870314  
8561  
TALLMAN ROAD  
60' R.O.W.

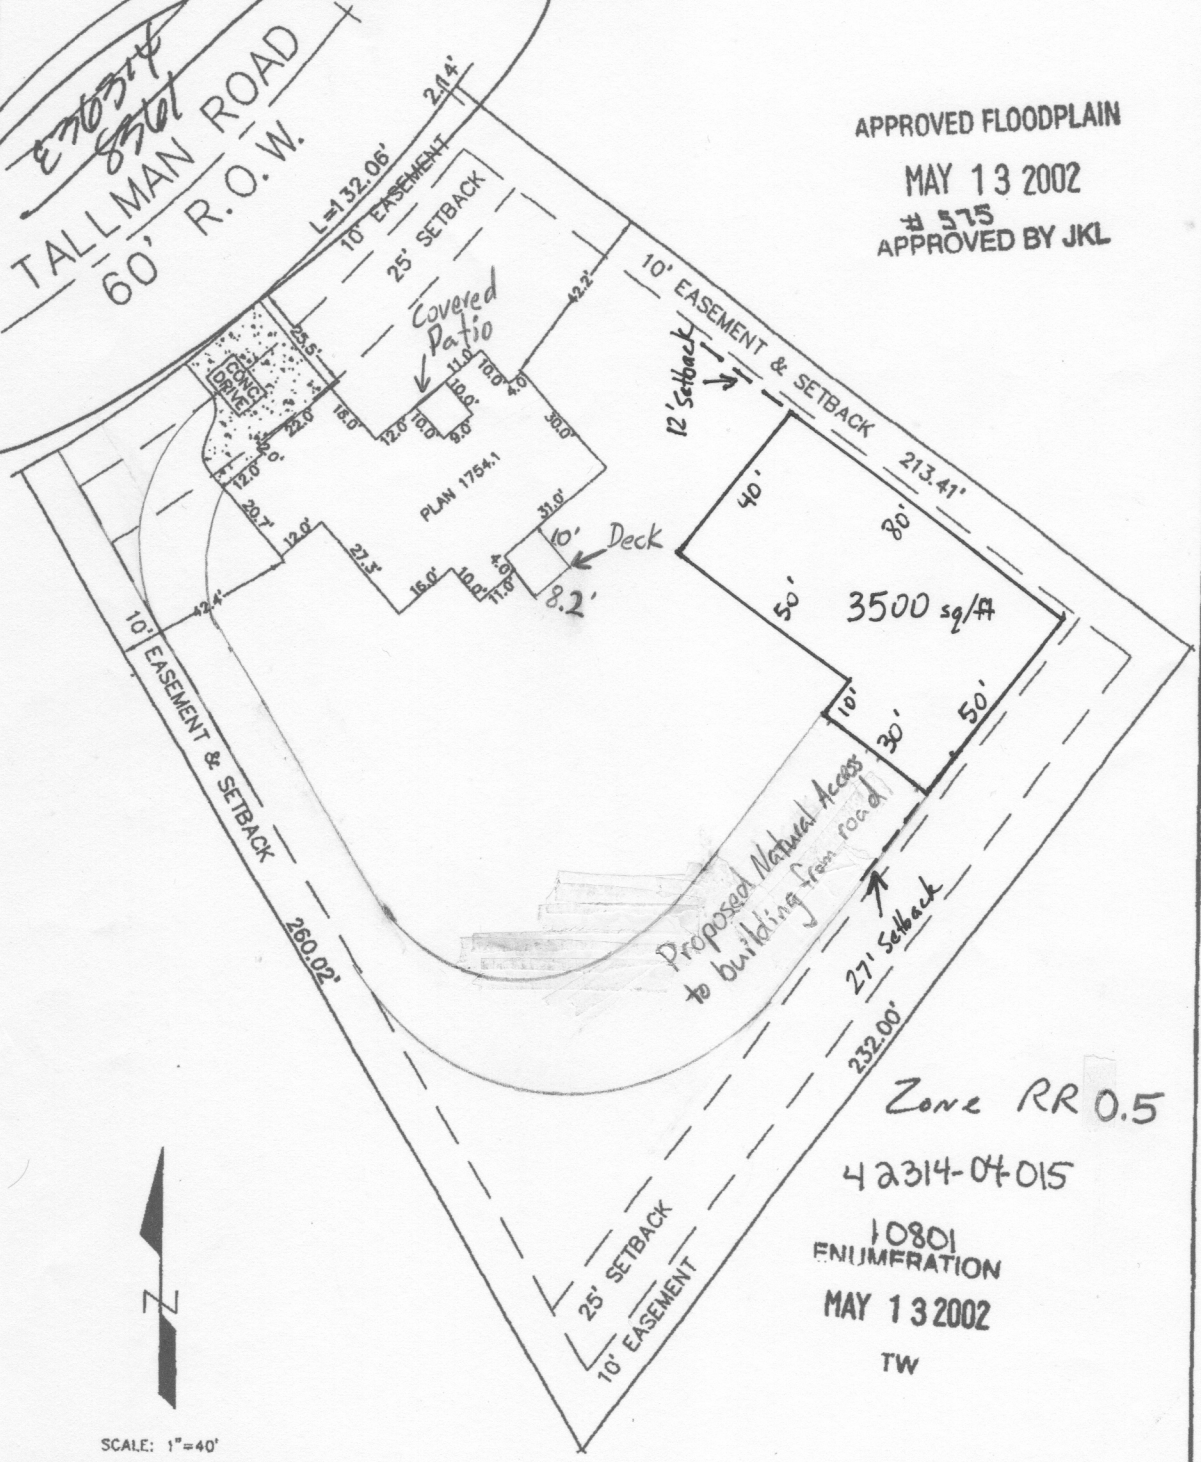
Show the proposed driveway access to the accessory building from the existing driveway. Label the surfacing for the proposed driveway.

Label as proposed 3500 sf accessory building

Footprint depicted is 2738 square feet, not 2926 square feet as mentioned in Letter of Intent. If decks or porches are not depicted in the site plan above, then it needs to be updated as well as number below
